BAYSIDE COUNCIL SUBMISSION SSD-9691 – ORICA SOUTHLANDS WAREHOUSE ESTATE

Council's Submission on SSD-9691

Council understands that consent for the following development is now sought:

'A warehouse and distribution facility including the construction of two warehouse buildings, ancillary office space and hardstand/car parking areas on an elevated concrete platform above the flood storage area.'

Swept Path Analysis

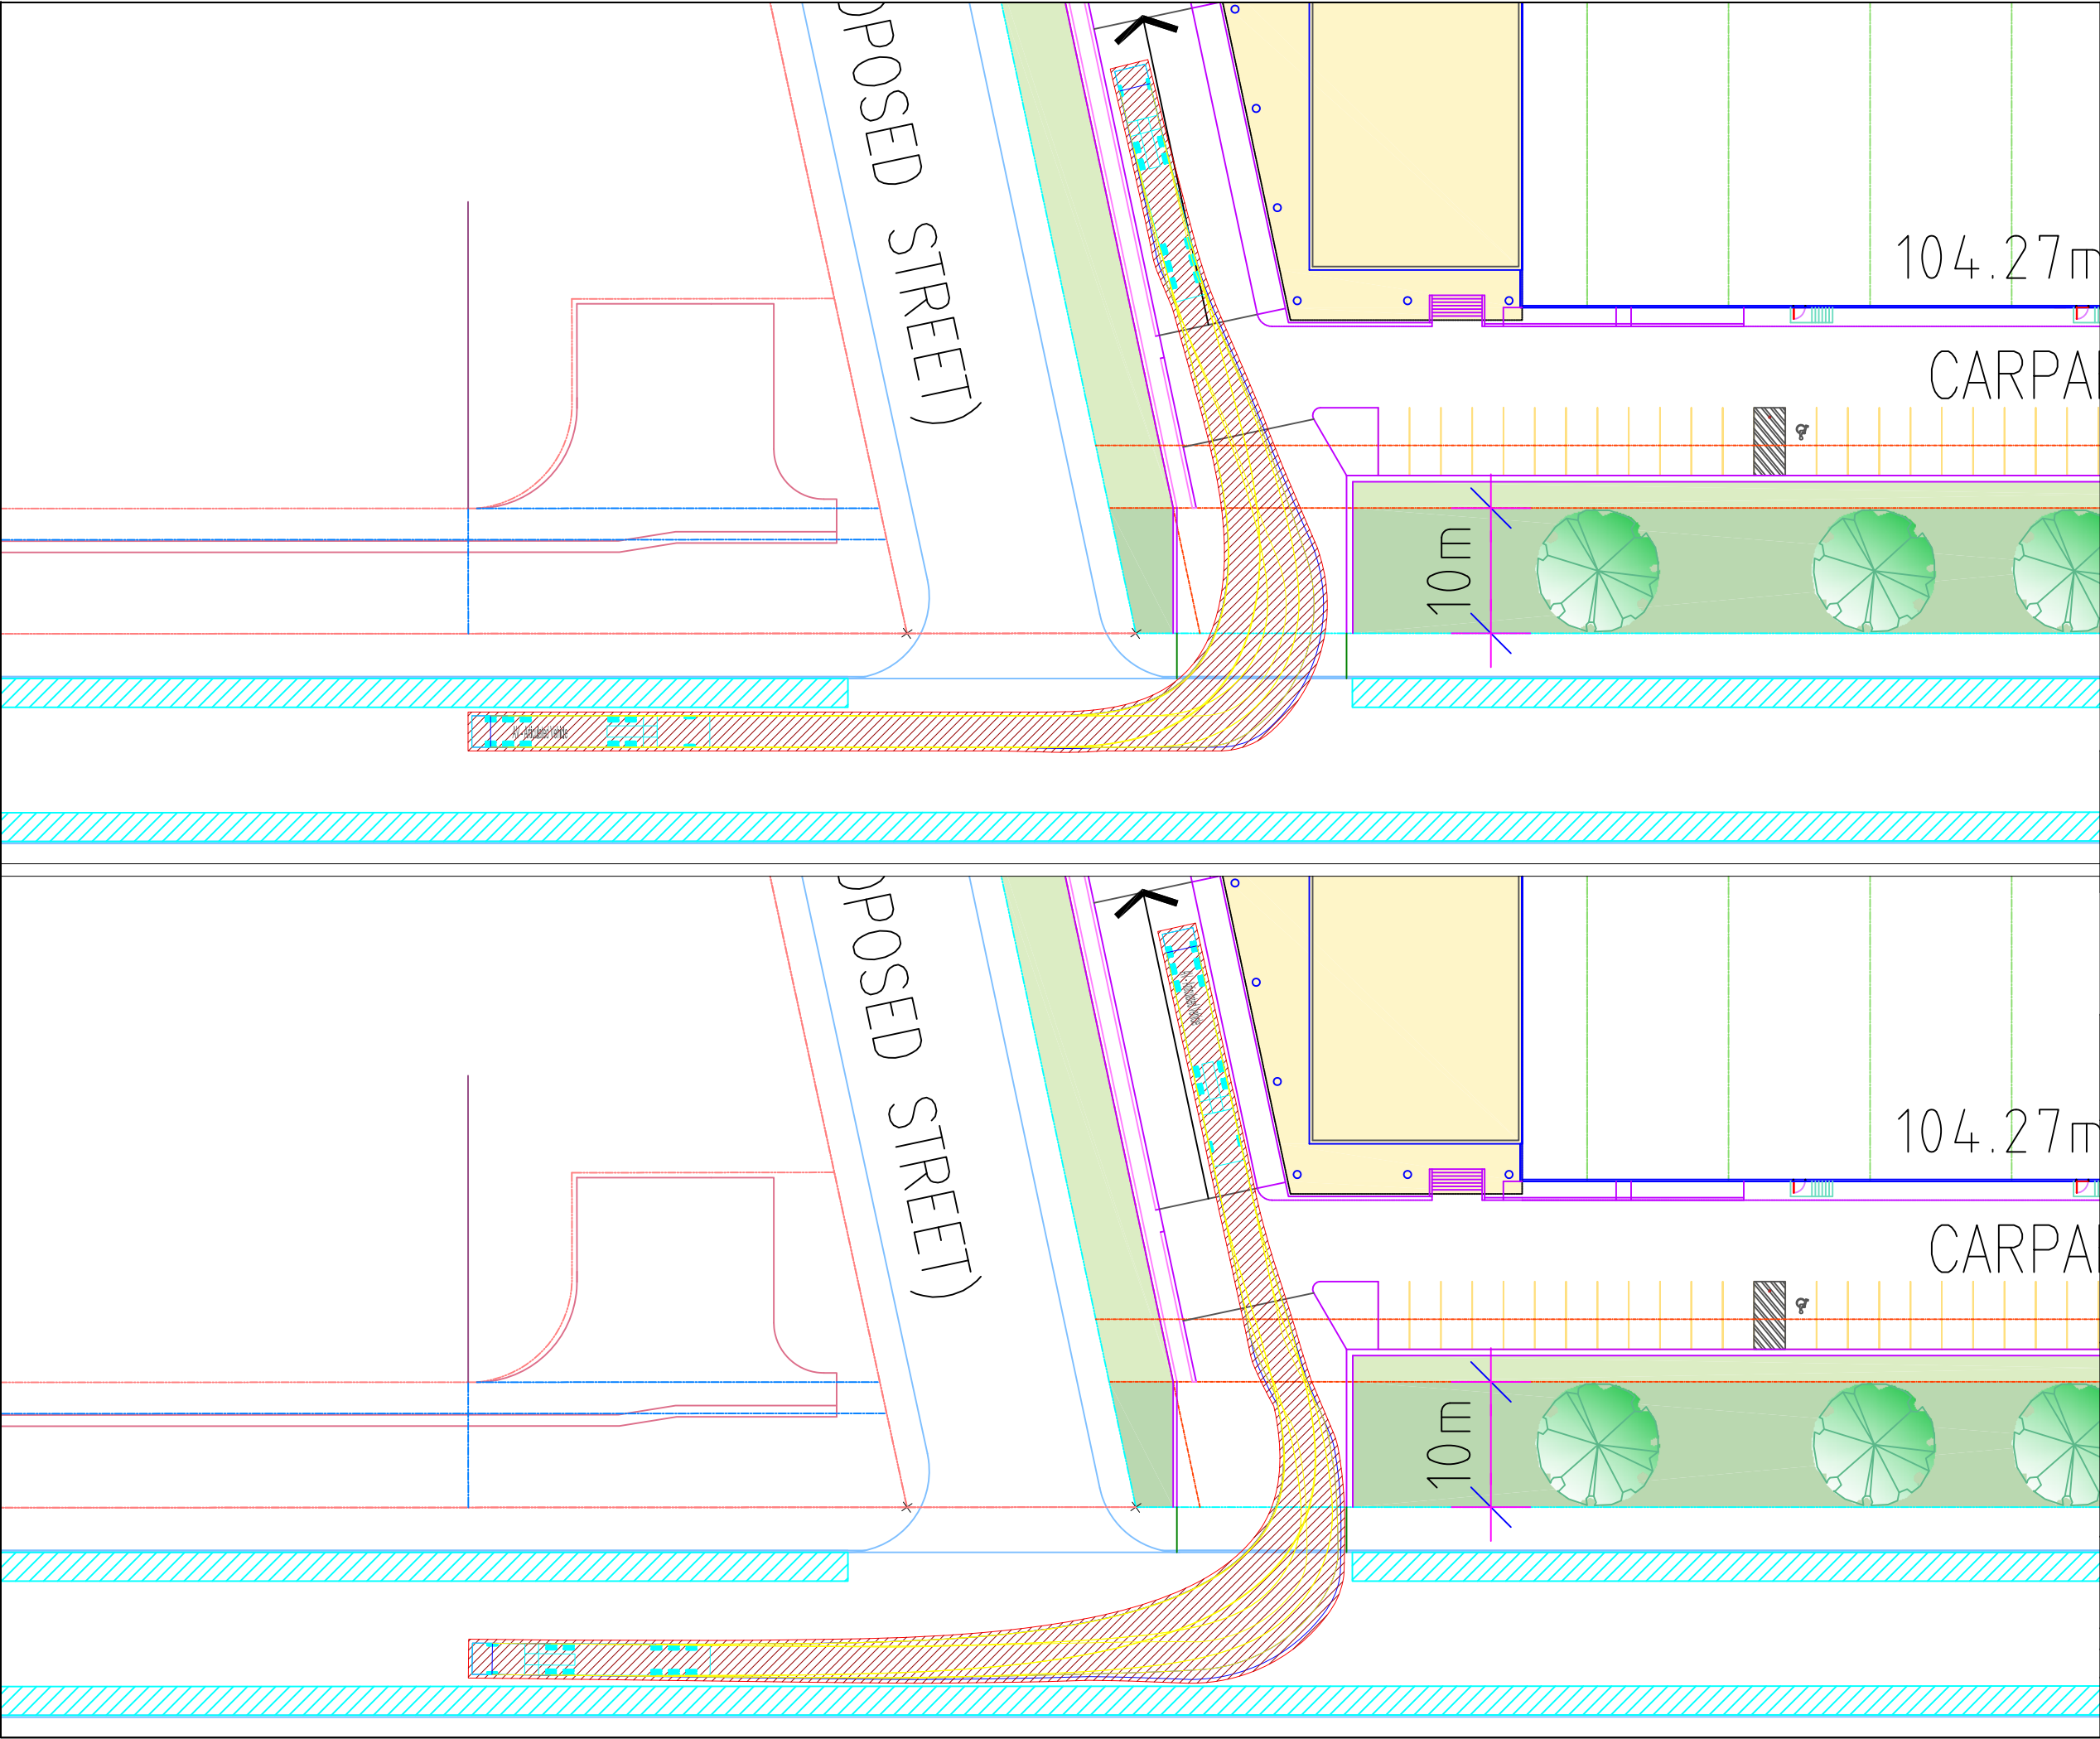
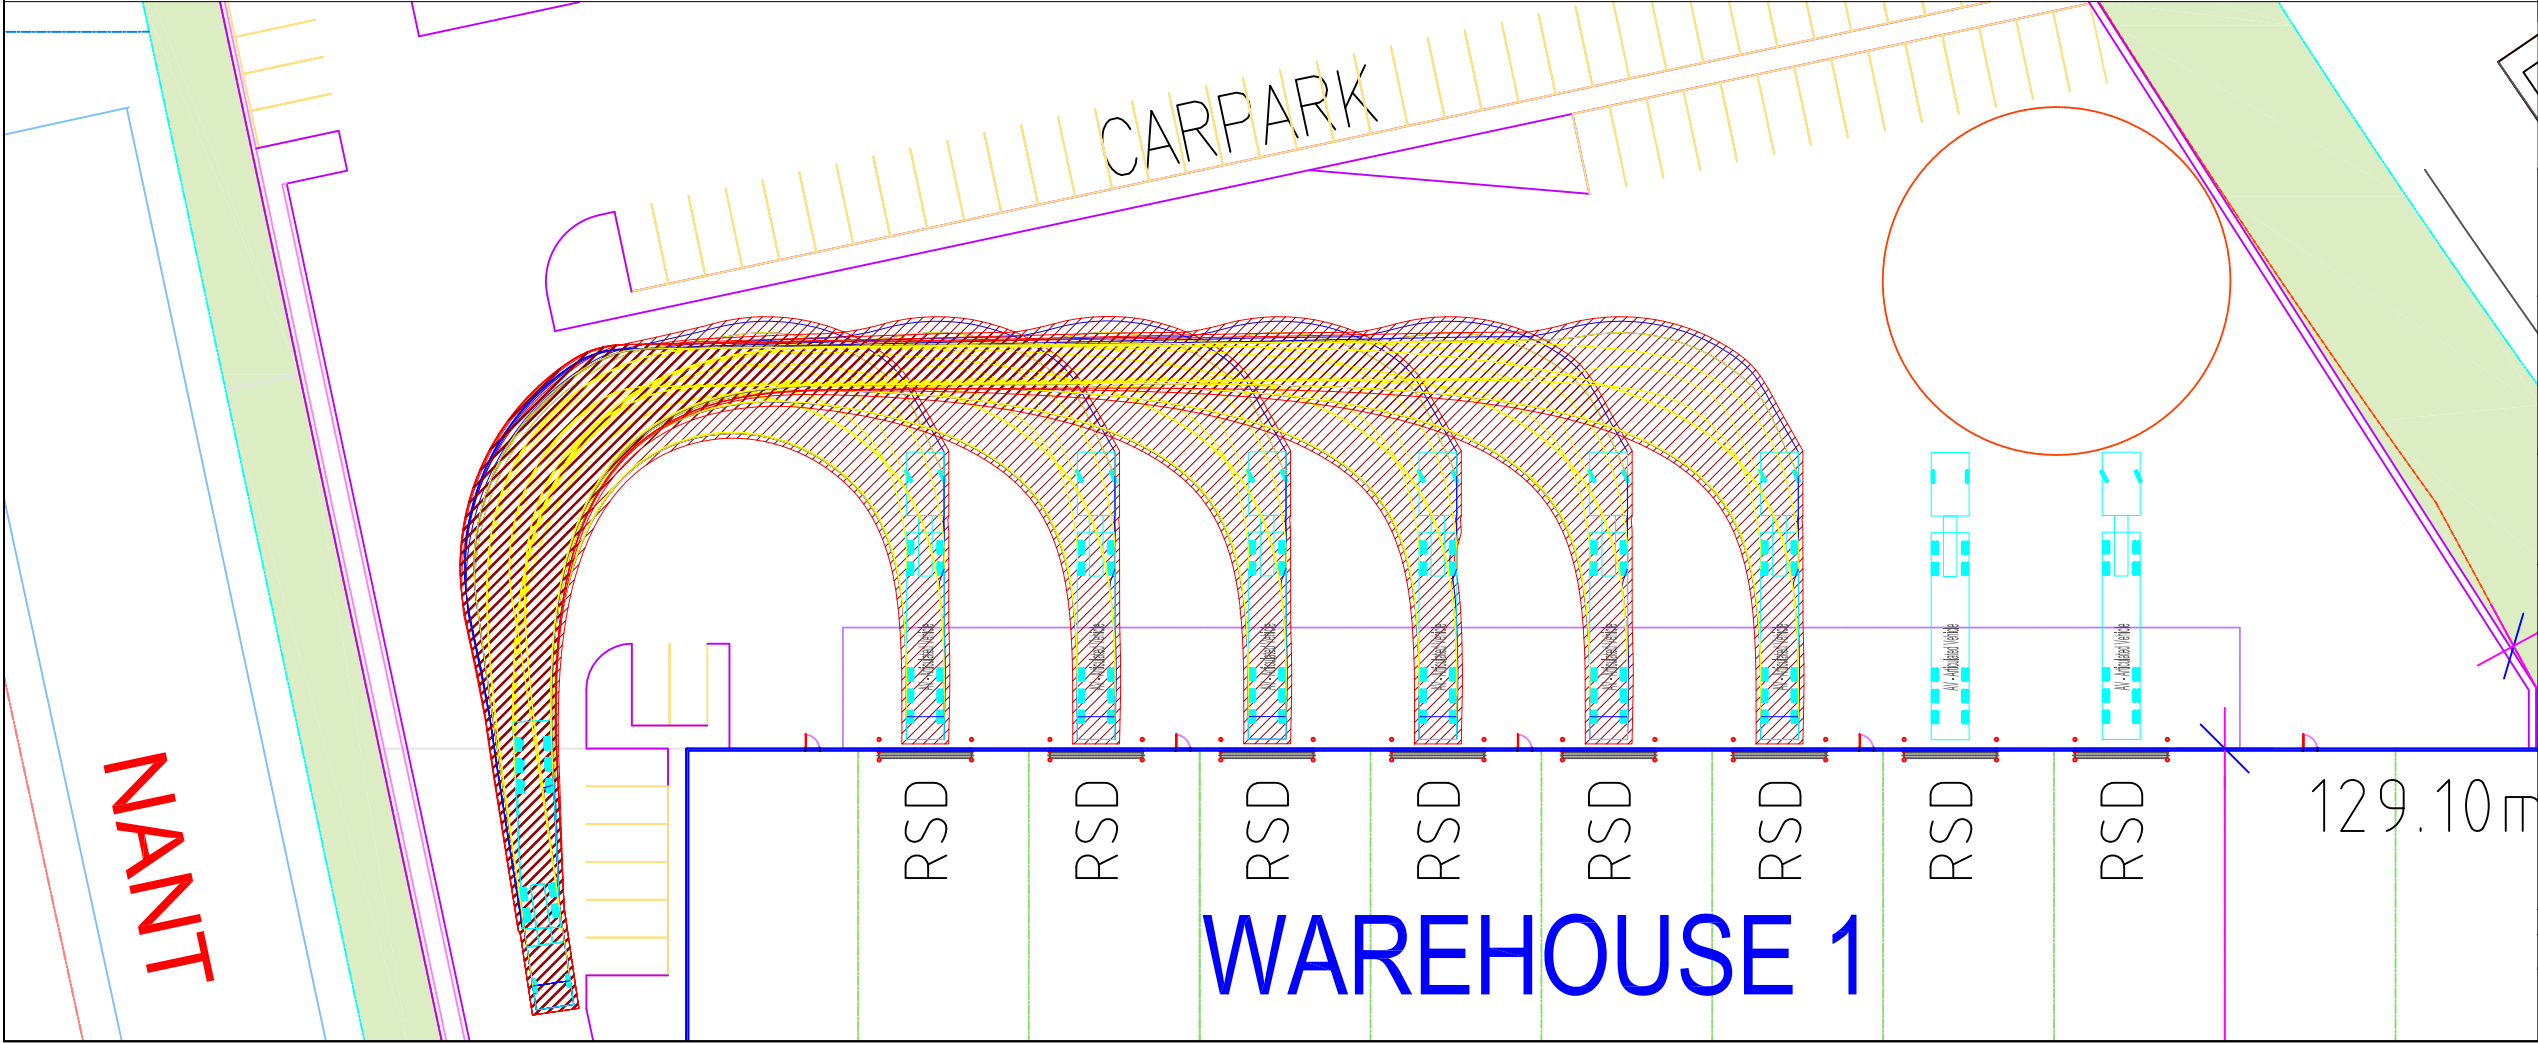
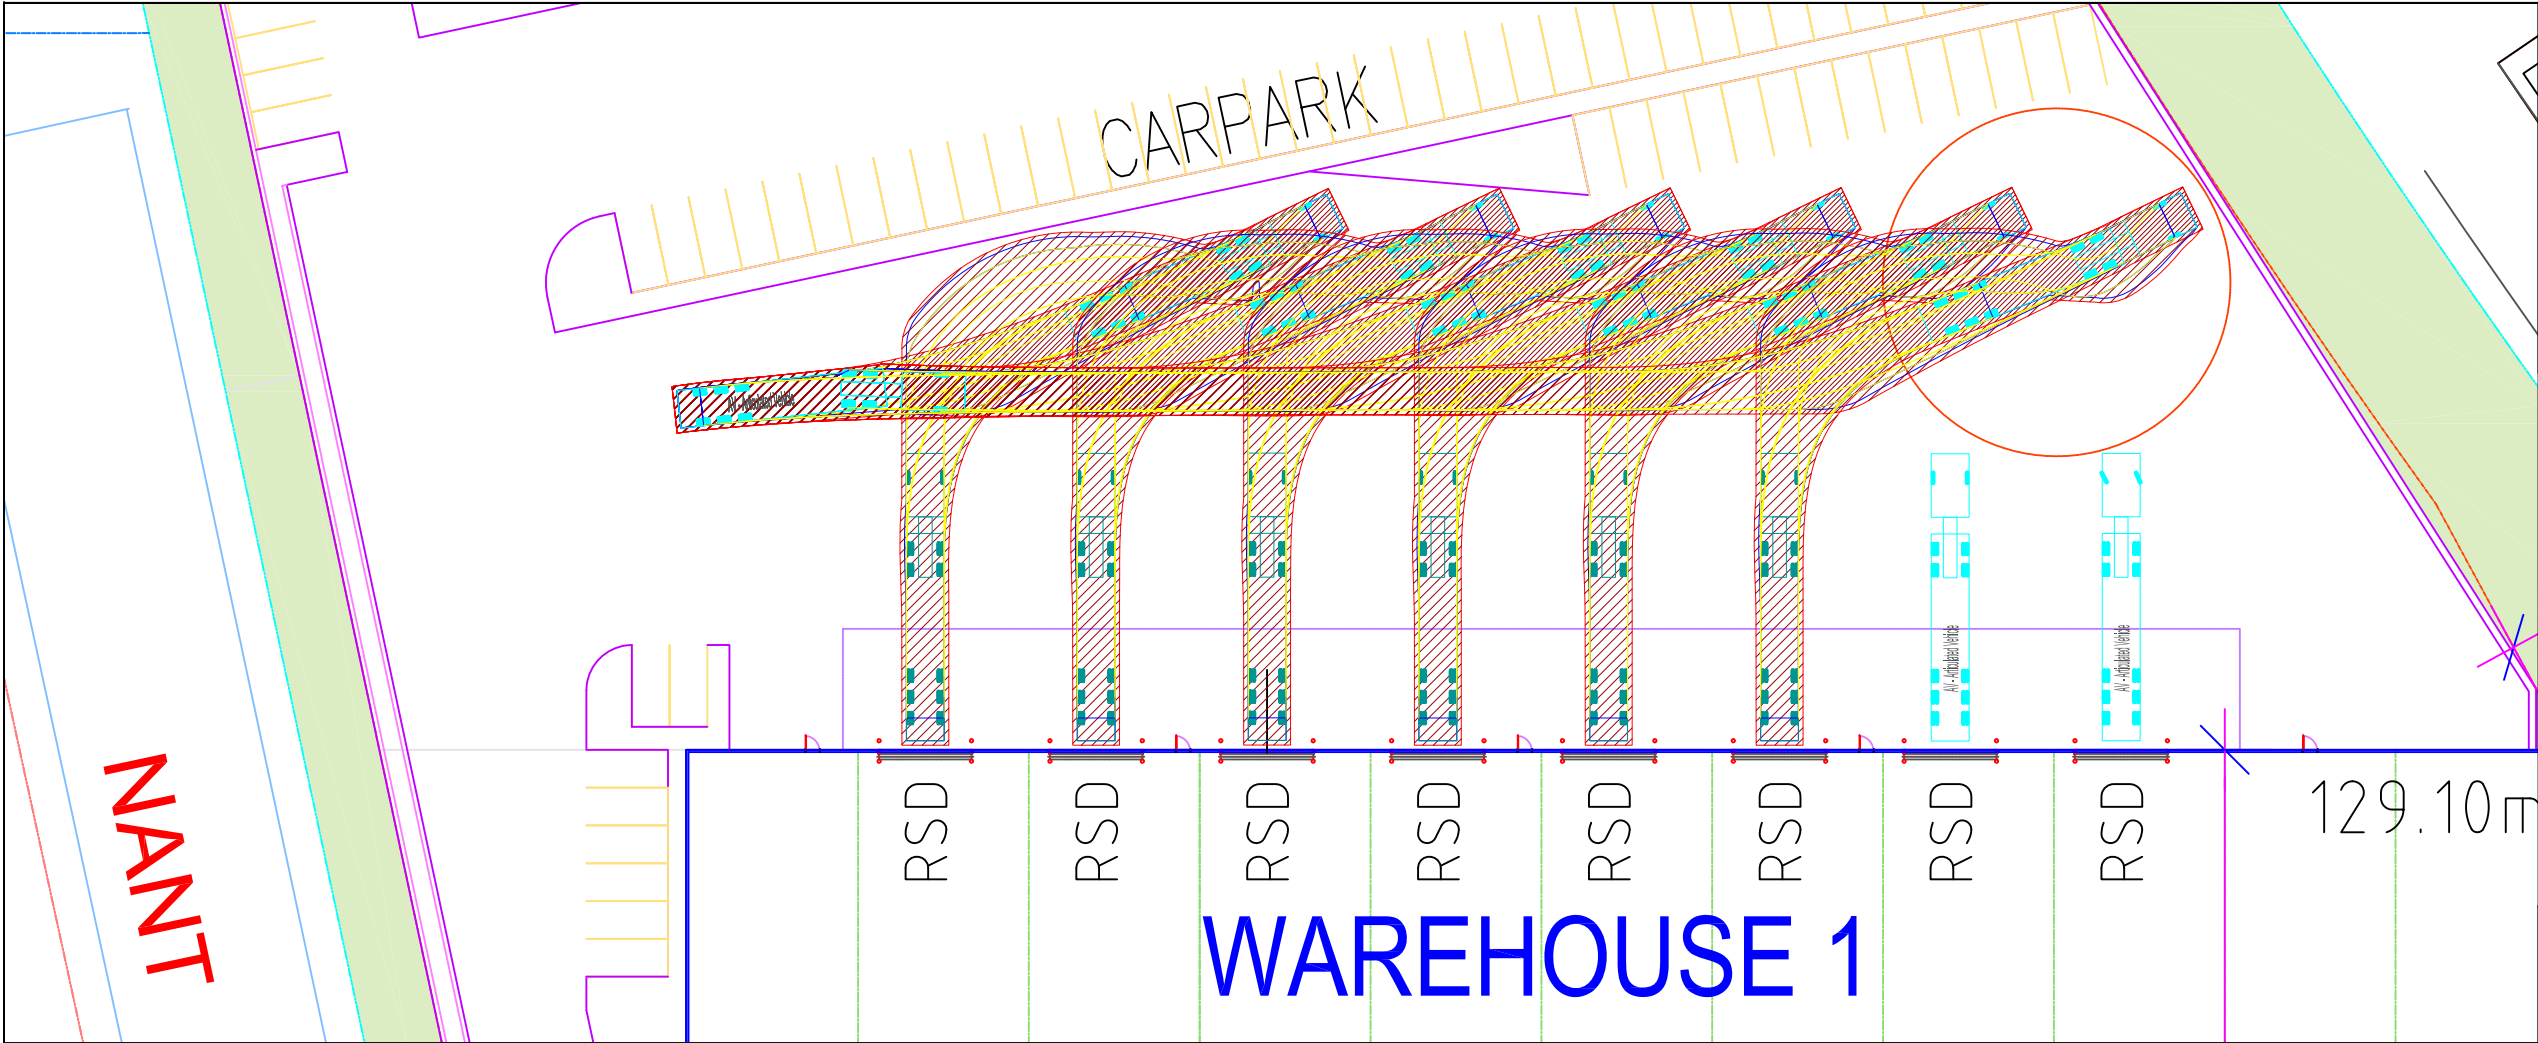
- The access width of 8 metres appears to only narrowly accommodate the B-doubles entry and exit and should be about 12.5m at least, as per AS2890.2;
- The applicant should be requested to provide a secondary access driveway or demonstrate the queuing in and out can be accommodated in a combined driveway;

- Swept paths need to detail how two truck vehicles driving in opposing directions can enter and exit the site simultaneously through the driveway;
- The western car park adjacent to the proposed Warehouse 1 is also within close proximity of the swept paths of B-doubles. Whilst there is no issue with the current arrangement, issues may arise if they intersect with the parking spaces and/or structures;
